HAYES STRUCTURAL

Date: March 7, 2024

Re: 23-FRM-022
Framing Inspection
Lot 18 Tobacco Road
209 Golden Leaf Farms Rd.
Angier, NC 27501
Permit No.: SFD2401-0083

At your request, a site visit was made to the above referenced single family residence under construction to inspect several I-joists within the first and second floor systems that were cut to install plumbing.

First Floor Framing Plan
Elevation 'P'

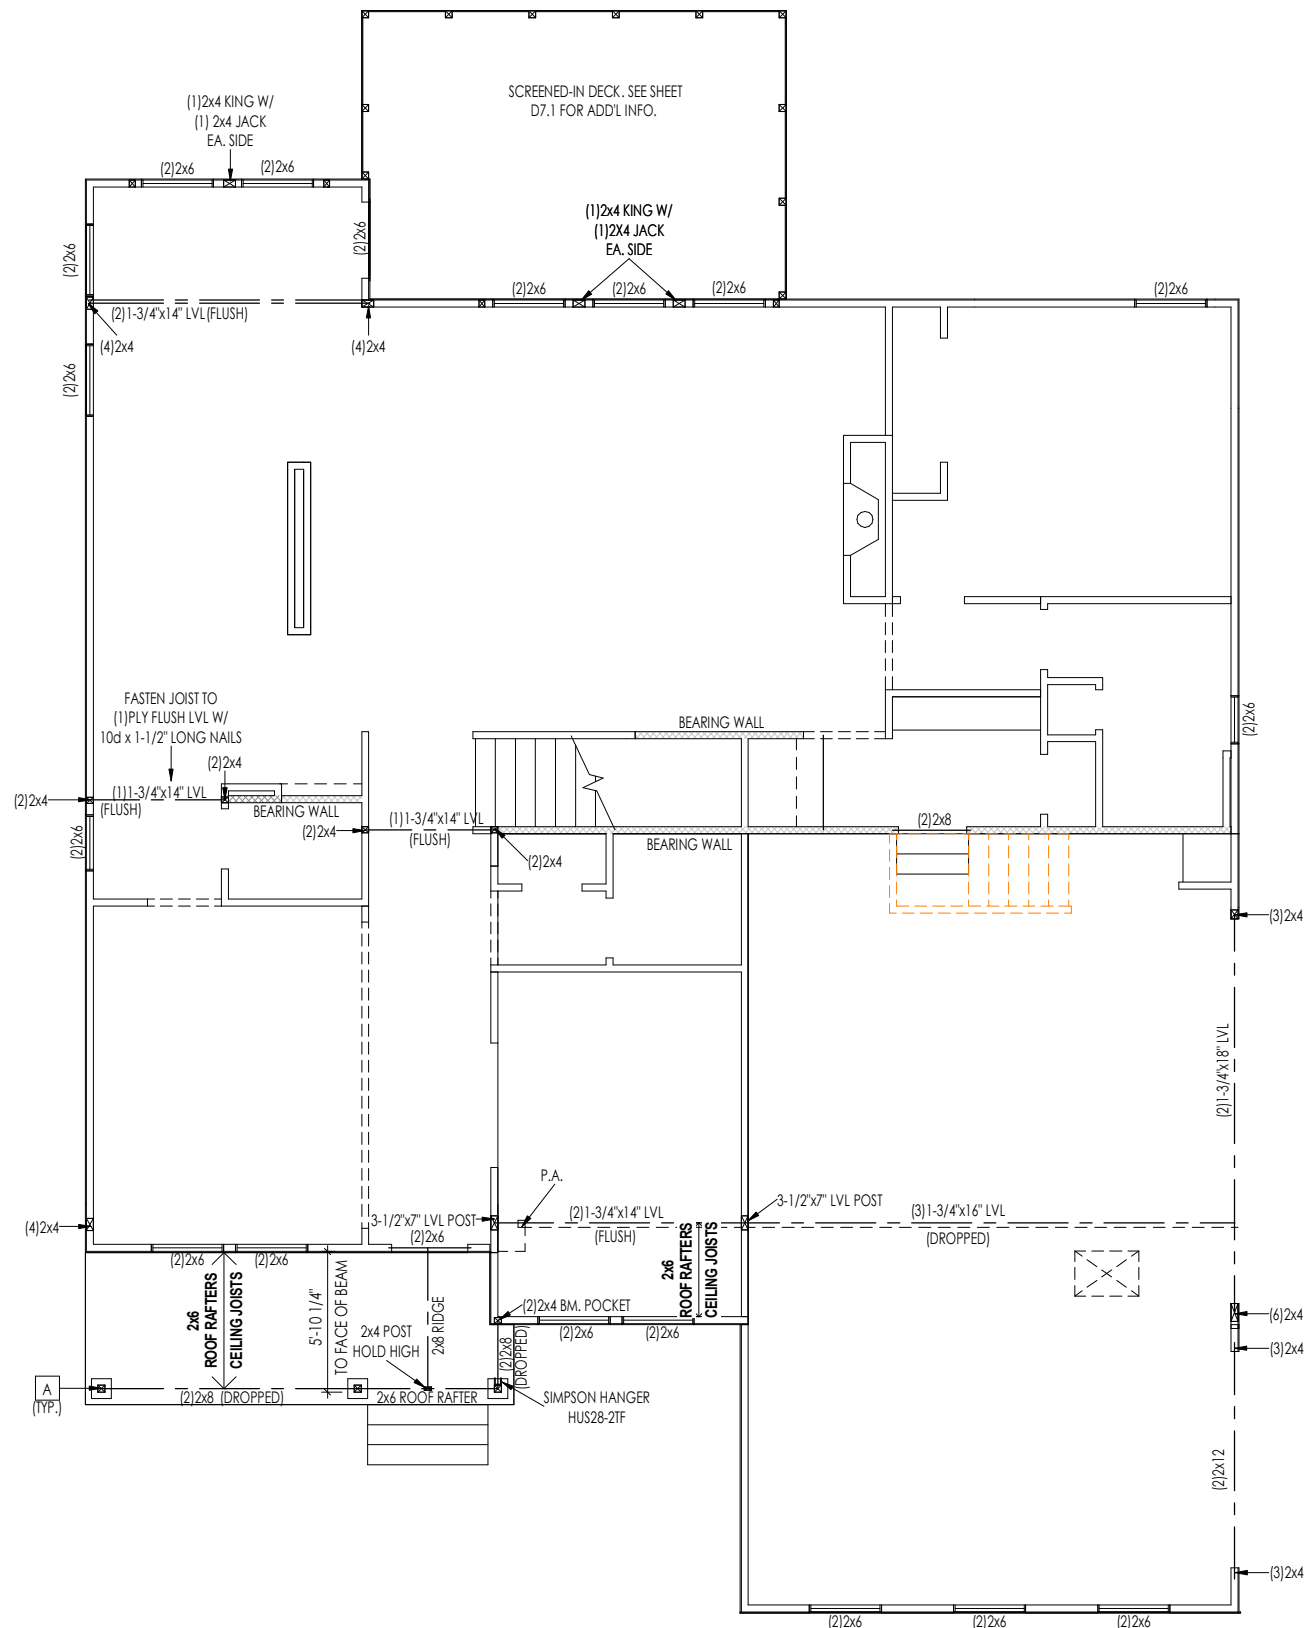
1. The second I-joist from the right foundation wall within the first floor system beneath bath #3 had a +/- 20" section cut out approximately 3" from the rear garage foundation wall to install the toilet drain.

2. The first I-joist from the left garage foundation wall within the first floor system beneath the powder room had a +/- 20" section cut out approximately 7" from the girder to install the toilet drain.

1. The cut ends of the second I-joist are to be supported by a +/- 17" long 14" BCI 5000s-1.8 (or equivalent) I-joist header installed between the first and third I-joists from the right foundation wall. The I-joists supporting the headers are adequate without reinforcement. The headers are to be fastened to the supporting joists and the cut ends of the second joist are to be fastened to the headers with face-mount I-joist hangers. The webs of the I-joists are to be packed out with OSB per the manufacturer's specifications prior to hanger installation.

2. The cut ends of the first I-joist are to be supported by a +/- 17" long 14" BCI 5000s-1.8 (or equivalent) I-joist header installed between the left garage foundation wall and second I-joist from the foundation wall. The I-joist supporting the header is to be reinforced with a full-length 14" BCI 5000s-1.8 (or equivalent) I-joist prior to header installation. Doubled I-joists are to be fastened at the top and bottom flanges with (1) row of 3½" long Simpson Strong-Tie SDS (or equivalent) screws spaced 12" o.c. The headers are to be fastened to the supporting joist and the cut ends of the first joist are to be fastened to the headers with face-mount I-joist hangers. The webs of the I-joists are to be packed out with OSB per the manufacturer's specifications prior to hanger installation.

Second Floor Subfloor Plan
Elevation 'P'

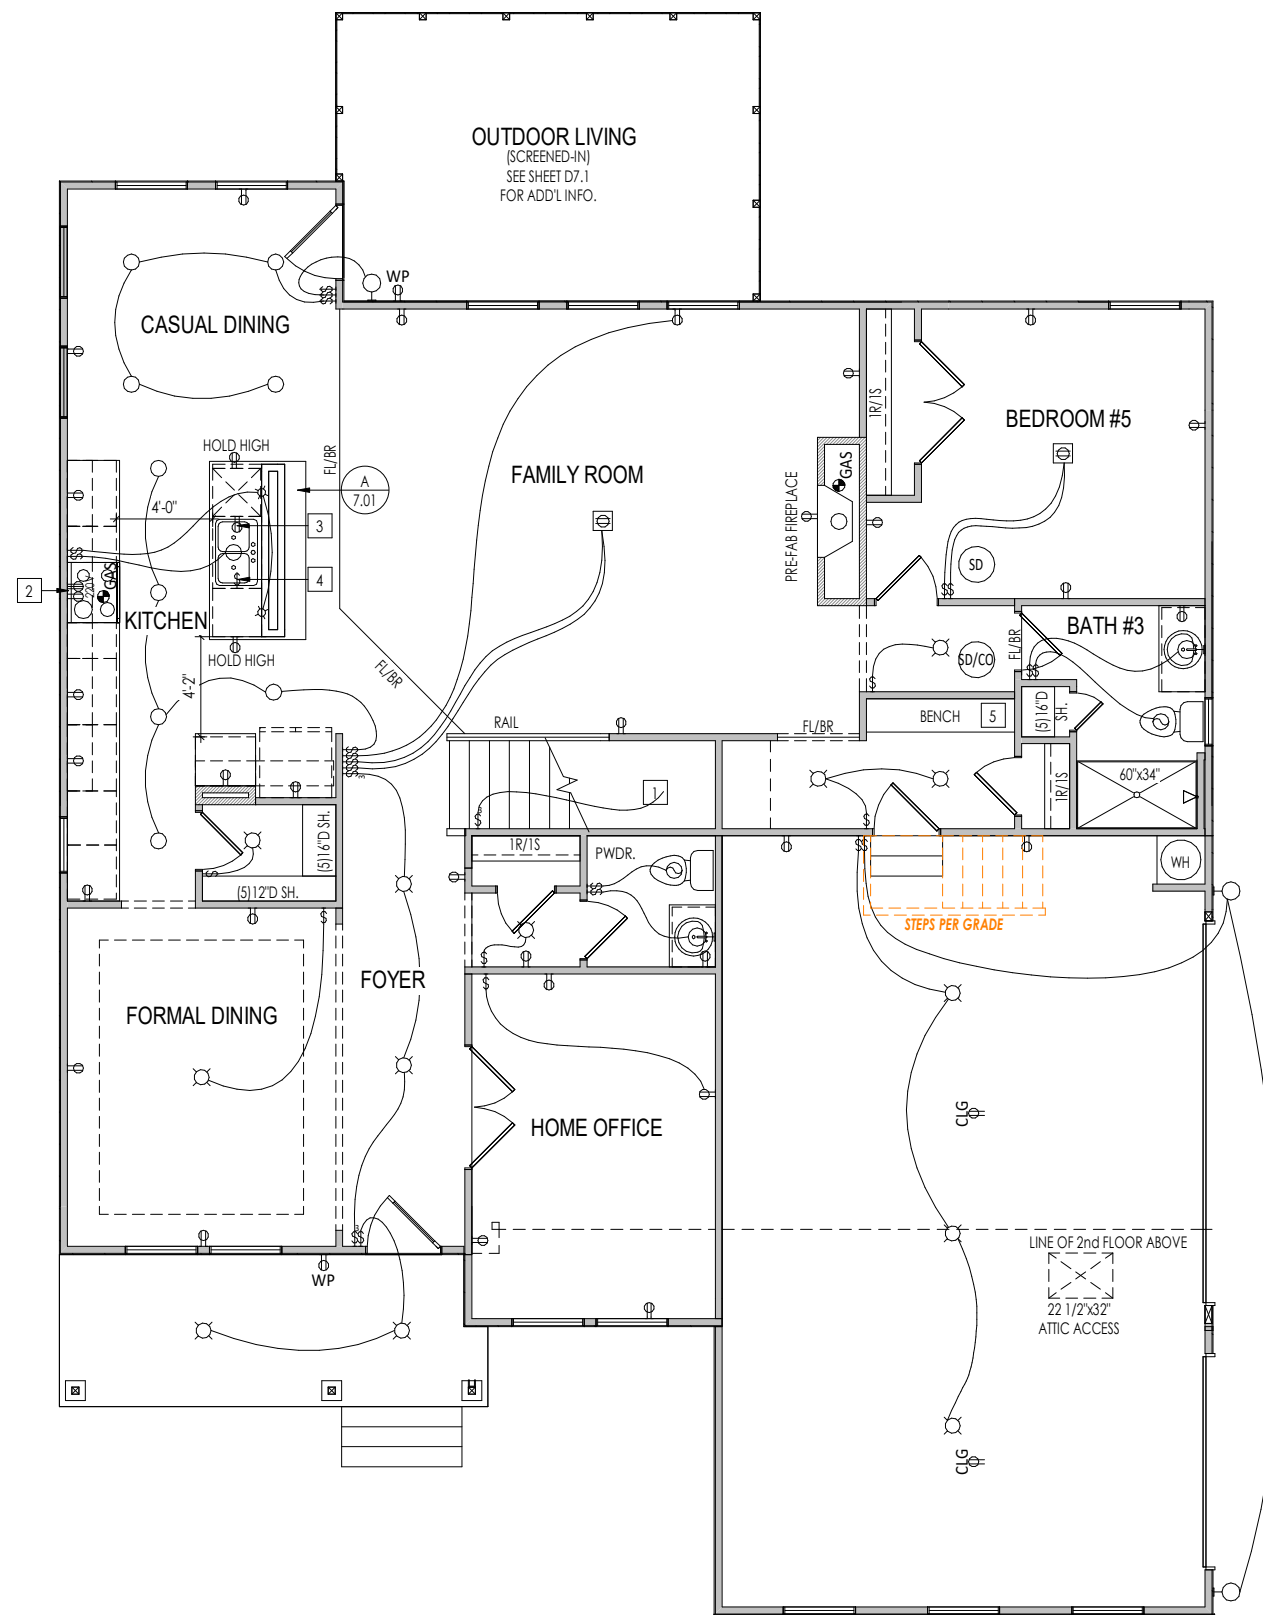
3. The seventeenth I-joist from the left exterior wall within the second floor system beneath the primary bath had a +/- 20" section cut out approximately 8'-0" from the rear exterior wall to install the shower drain. The cut ends of the joist were supported by a 14" I-joist header installed between the adjacent doubled I-joist and single I-joist.

4. The first I-joist from the right exterior wall within the second floor system beneath the hall bath had a +/- 20" section cut out approximately 6'-8" from the rear garage wall to install the toilet drain. The cut ends of the joist were supported by a 14" I-joist header installed between the right exterior wall and second I-joist from the wall.

3. The single I-joist supporting the right ends of the headers is to be reinforced with a full-length 14" BCI 5000s-1.8 (or equivalent) I-joist at the right side. The doubled I-joist supporting the left ends of the headers is adequate without reinforcement. Doubled I-joists are to be fastened at the top and bottom flanges with (1) row of 3½" long Simpson Strong-Tie SDS (or equivalent) screws spaced 12" o.c. The headers are to be fastened to the supporting

joists and the cut ends of the seventeenth joist are to be fastened to the headers with face-mount I-joist hangers. The webs of the I-joists are to be packed out with OSB per the manufacturer's specifications prior to hanger installation.

4. The I-joist supporting the left ends of the headers is to be reinforced with a 14" BCI 5000s-1.8 (or equivalent) I-joist at the left side spanning from the rear garage wall to the rear exterior wall. Doubled I-joists are to be fastened at the top and bottom flanges with (1) row of 3½" long Simpson Strong-Tie SDS (or equivalent) screws spaced 12" o.c. The headers are to be fastened to the supporting joist and the cut ends of the first joist are to be fastened to the headers with face-mount I-joist hangers. The webs of the I-joists are to be packed out with OSB per the manufacturer's specifications prior to hanger installation.
